POST EPC MEMORANDUM

RE: PR-2022-007103_SI 2023-00693 –Site Plan-EPC_3200 Broadway Blvd. SE Travel Stop

The agent (Tierra West) for the Loves Travel Stop Located at 3200 Broadway Blvd. SE, has worked with Staff to fulfill post EPC requirements to meet Conditions of Approval, 1-10. See EPC Notice of Decision (NOD) dated 6-15-2023.

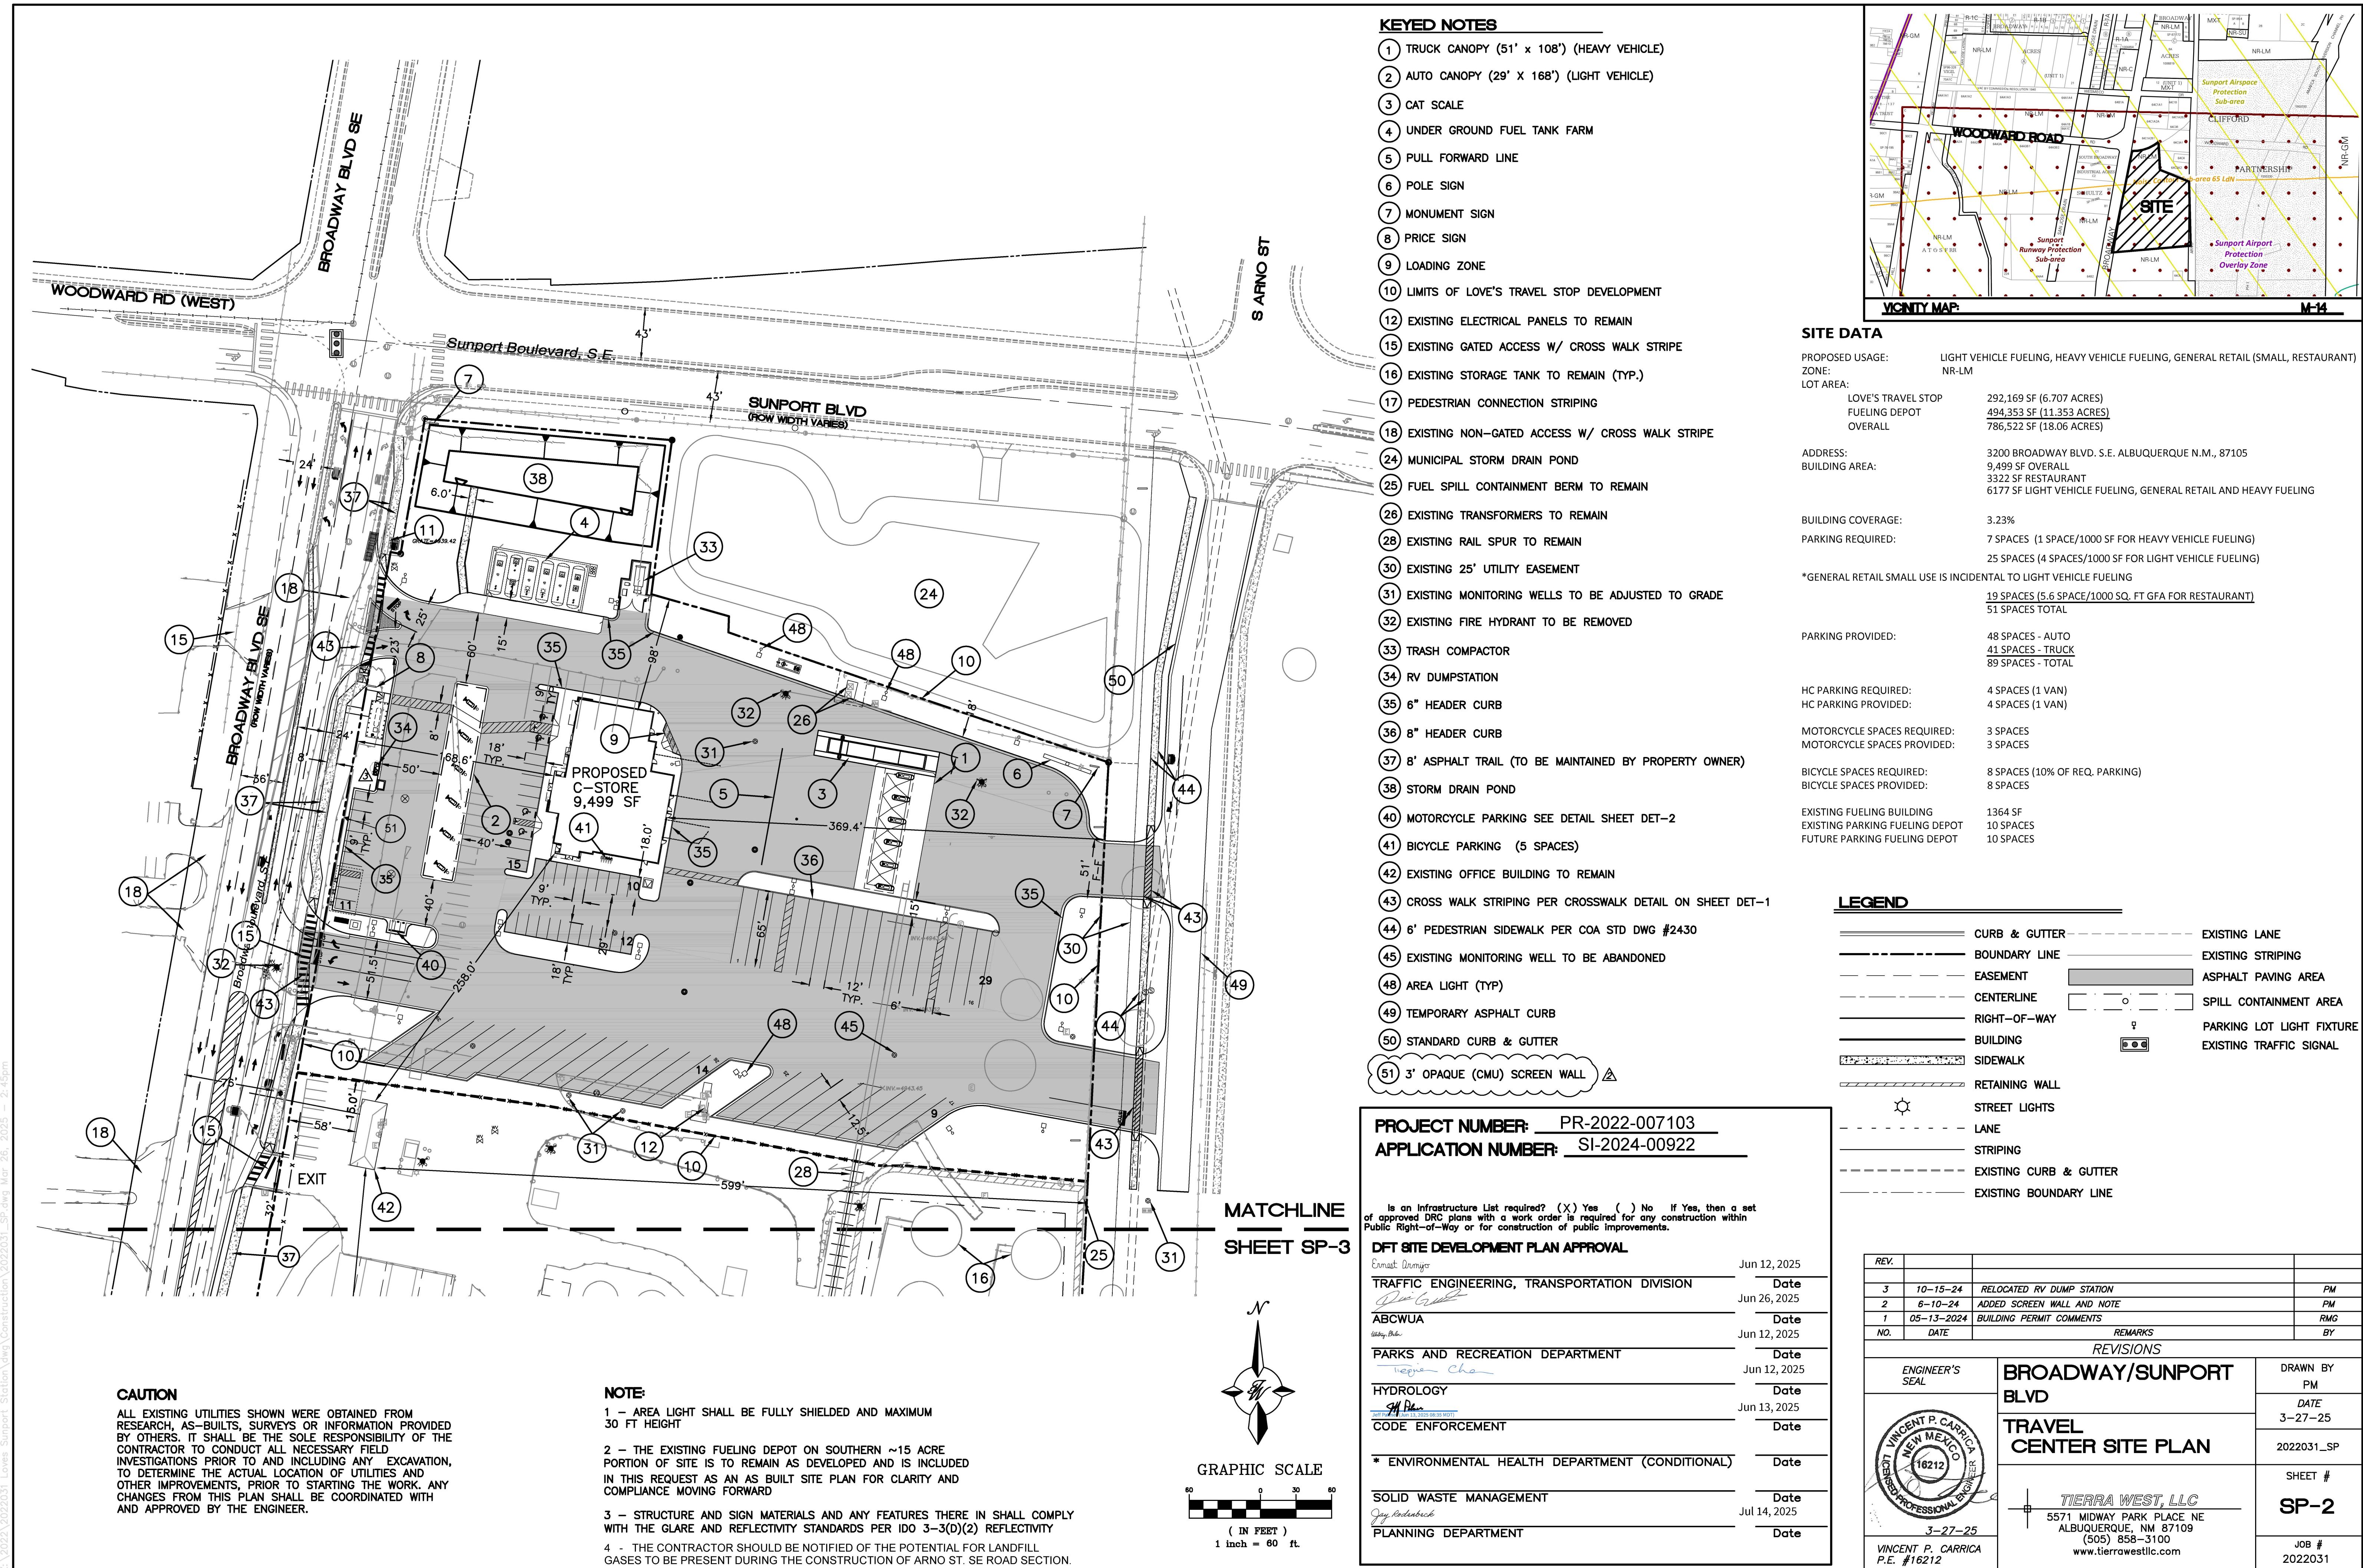
8. Condition 8 A: The applicant has added light pole details but have not clarified if they are pursuant to IDO 4-3(D)(17)(d).
9. Condition 8 B is satisfied.

**A** **WEST ELEVATION**  
Scale: 1/8" - 1'-0"

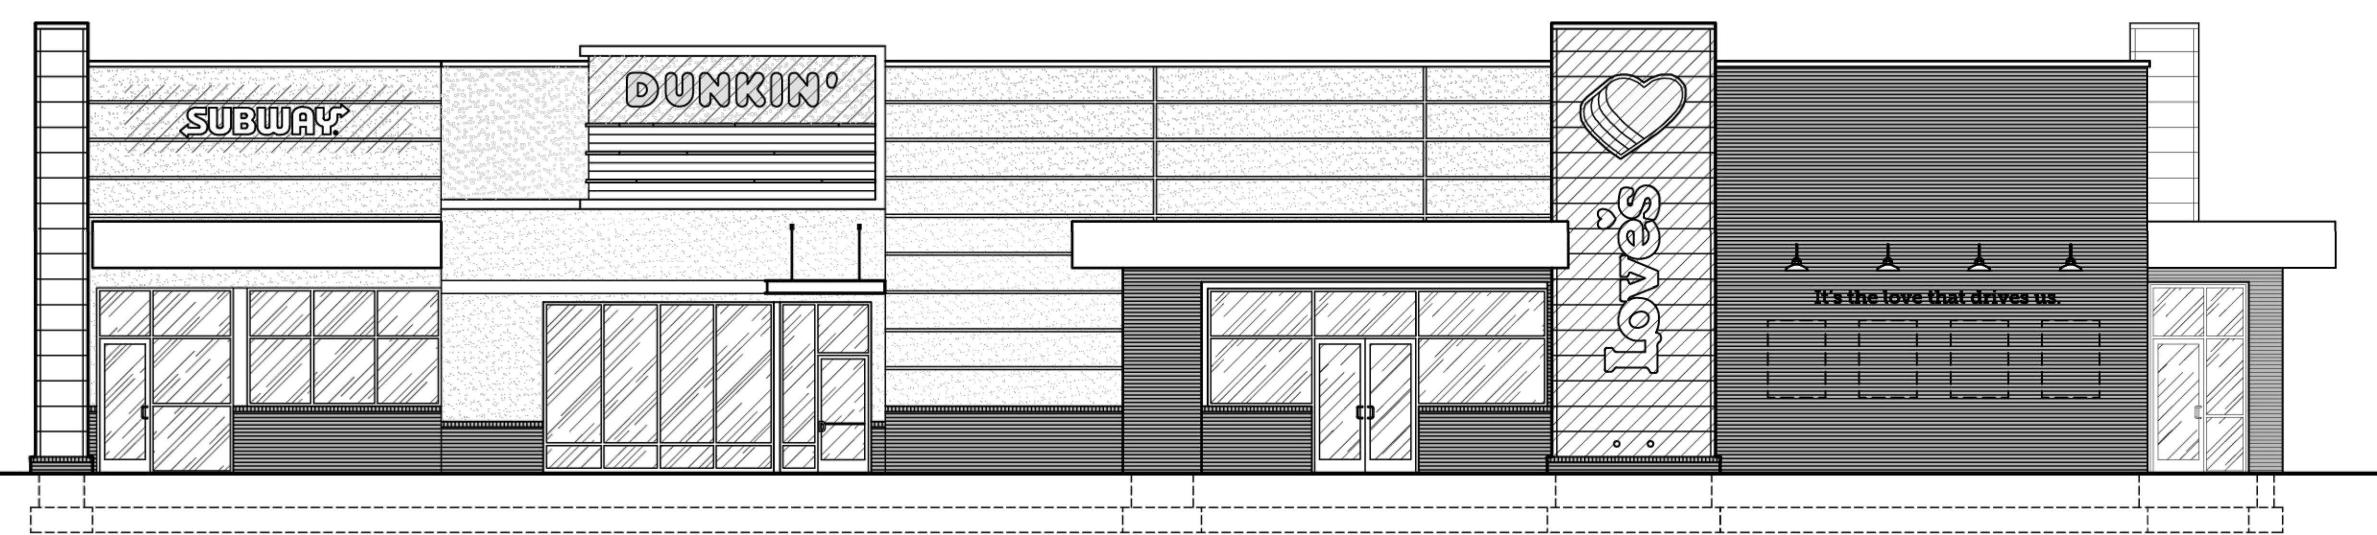
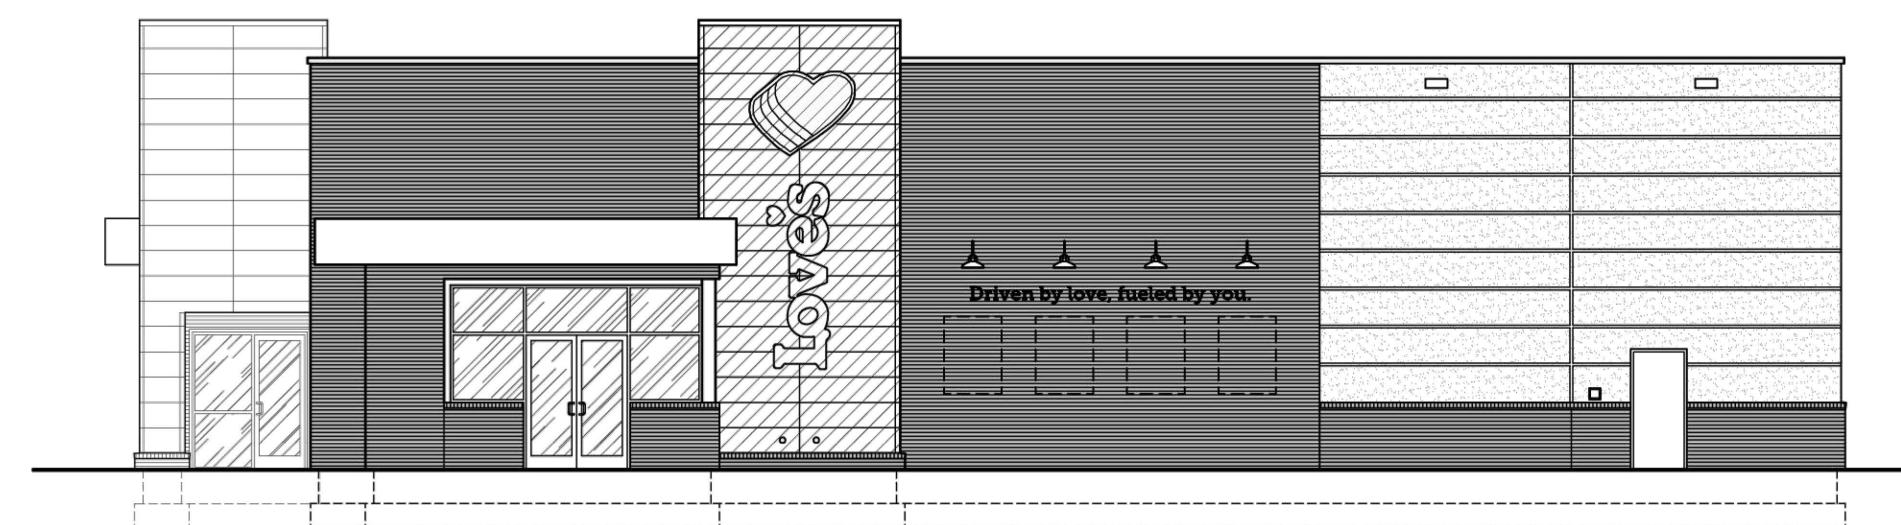
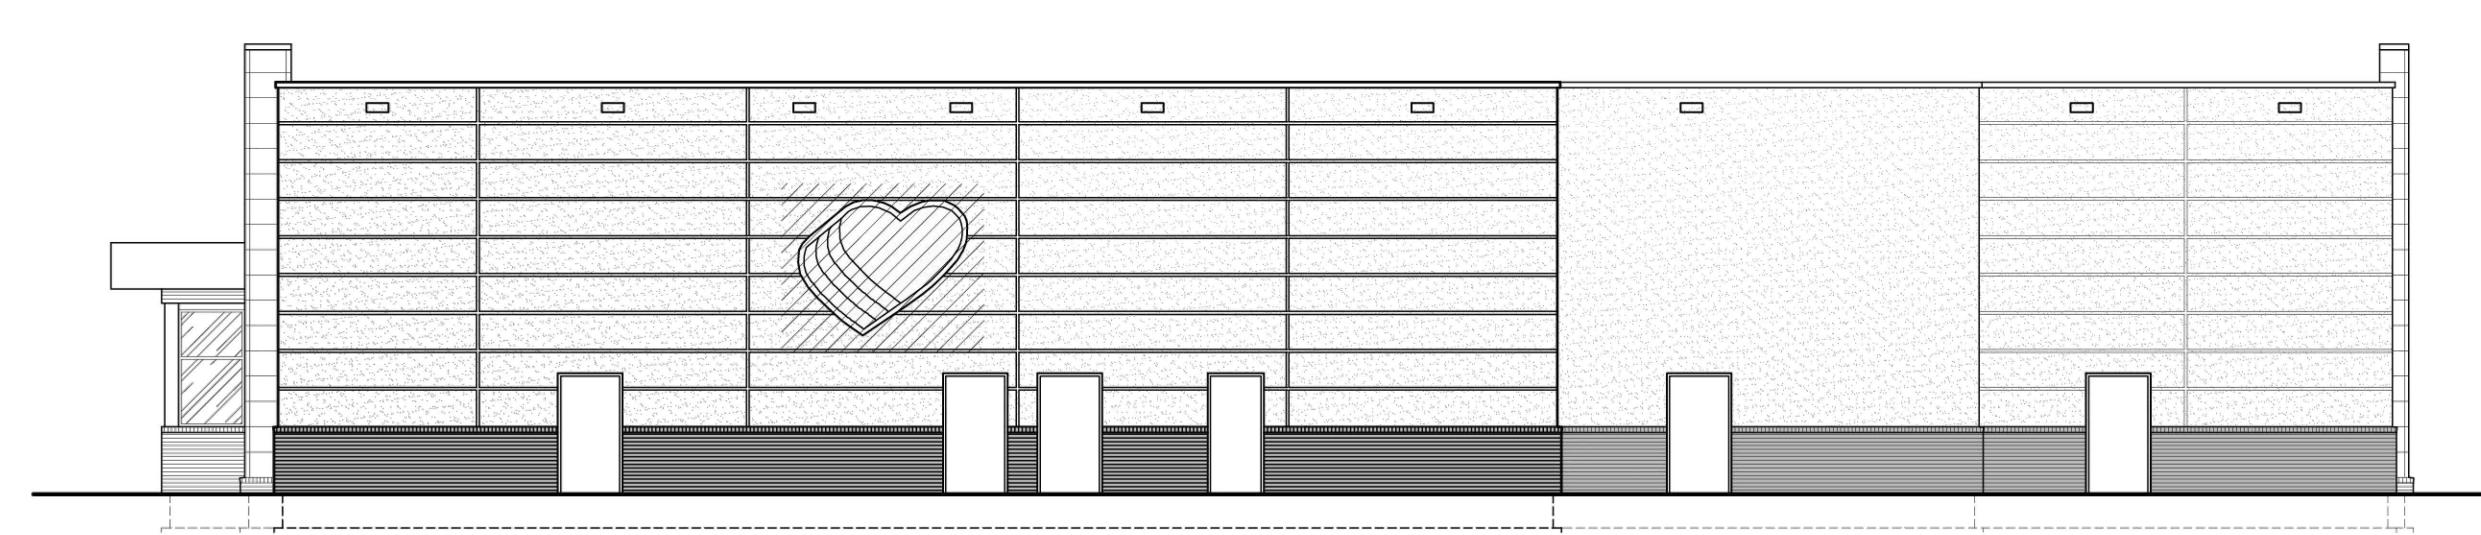
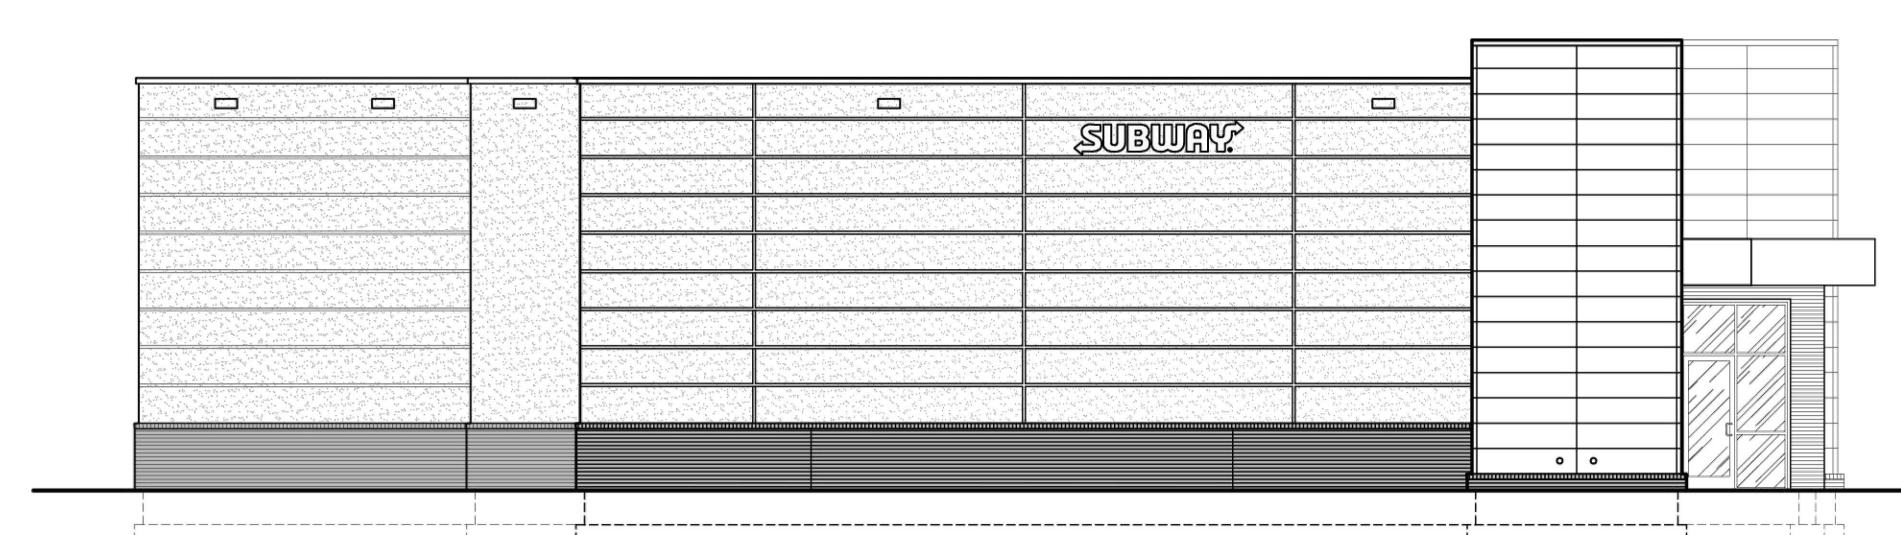
11. Condition 9 B: The LRV does not appear to have been added to all surfaces and signs pursuant to IDO 3-3(D)(2) Reflectivity.
